**WELWYN HATFIELD BOROUGH COUNCIL  
EXECUTIVE DIRECTOR - PLANNING, PUBLIC PROTECTION AND GOVERNANCE**

**DELEGATED APPLICATION**

**Application No:** N6/2013/2092/AD  
**Location:** Howardsgate Welwyn Garden City AL8 6BB  
**Proposal:** Installation of fascia and projecting sign and window vinyls  
**Officer:** Mr S Dicocco

**Recommendation:** Refused

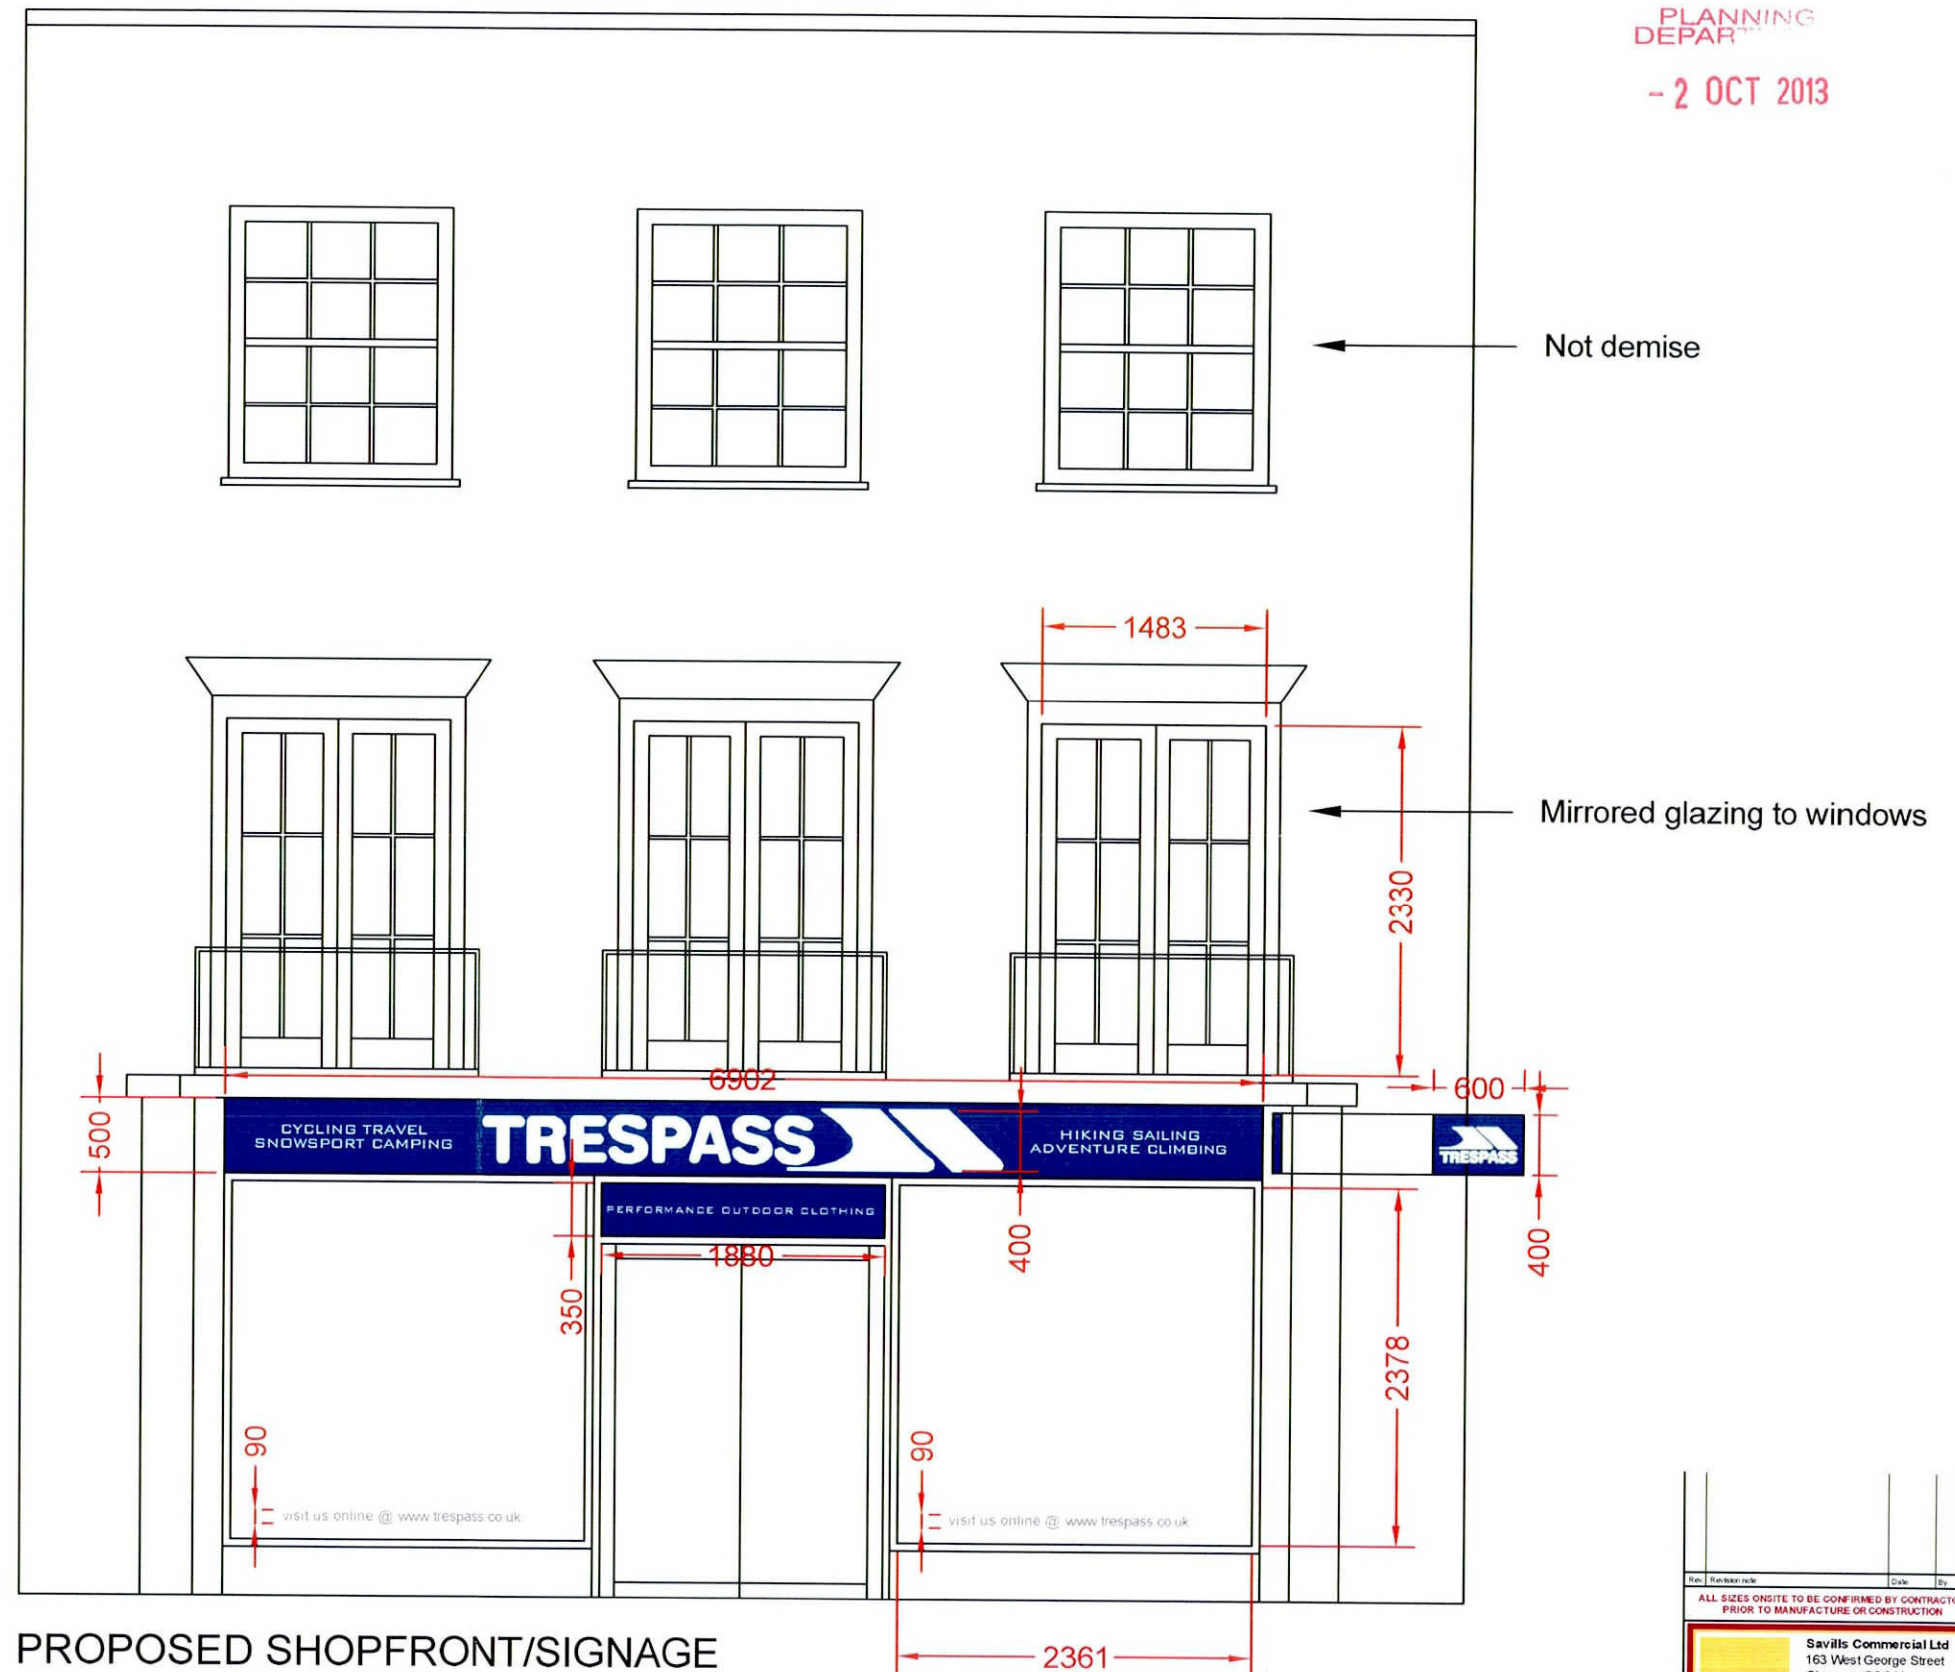
The proposed sign would not accord with the Supplementary Design Guidance for box signs on designed entablatures in regards to the blue background covering the full width of the fascia. The sites fascia is not exceedingly deep, and as such, it is considered that the internally illuminated 'box' signs depth, between 0.05 and 0.1m, would likely exceed the depth of the fascia.

Although the sign would be contained within the shopfronts entablature, it is considered that the width of the coloured background of the 'box' sign, alongside its depth and its proximity to the designed entablature, would disrupt the continuity and appearance the entablature which is a feature of this part of the conservation area.

It is not considered that the proposed internally illuminated 'box' fascia signage would detract from any architectural or historical significance of the building in terms of the materials and method of illumination however the proposed sign would cause some harm to the significance of the heritage asset in terms of design, scale and detailing, in relation to the background colour and depth of the illuminated 'box' fascia sign and its coverage of the entablature.

<p>While the proposed sign does comply with parts of policies D1 and D2 of the Welwyn Hatfield District Plan, as expanded upon within the SDG, the proposed projecting box sign in this location is not considered appropriate. By virtue of the coloured background exceeding a third of the width of the fascia and the signage exceeding the depth of the fascia, the proposed signage would be of poor quality design which would harm the character and qualities of Welwyn Garden City town centre and would detract from the significance of shopfronts with designed entablature within Welwyn Garden City Conservation Area.</p> <p>The proposed projecting sign would be located at fascia height. Given its siting and dimensions, and its design, it would not appear unduly obtrusive when viewed from the street scene of Howardsgate. Its design would harmonise with the fascia depth and as such it satisfies the relevant criteria of the SDG.</p> <p>The proposed window vinyls and signage above the door, on the sub fascia, would be subservient in scale, design and prominence from that of the main shopfront. As such, no objection is made to them with regard to their impact on the visual amenities of the shopfront, host building and surrounding street scene of the conservation area. They would therefore accord with the above relevant aspects of the SDG and the aforementioned aims of policies D1 and D2 of the District Plan and the NPPF.</p>

1. The proposed fascia signage, by virtue of the scale, design and detailing, particularly its extent of colour coverage and depth, would appear overly prominent and detract from the significance of the continuity and appearance of shopfronts

with designed entablature. Accordingly, the proposed signage would fail to represent high quality design as it would not respect the visual amenities and thus character of the host shopfront, building and street scene within the Conservation Area, contrary to policies D1 and D2 of the District Plan, the Supplementary Design Guidance Statement of Council Policy 2005 and paragraph 67 of the National Planning Policy Framework 2012.
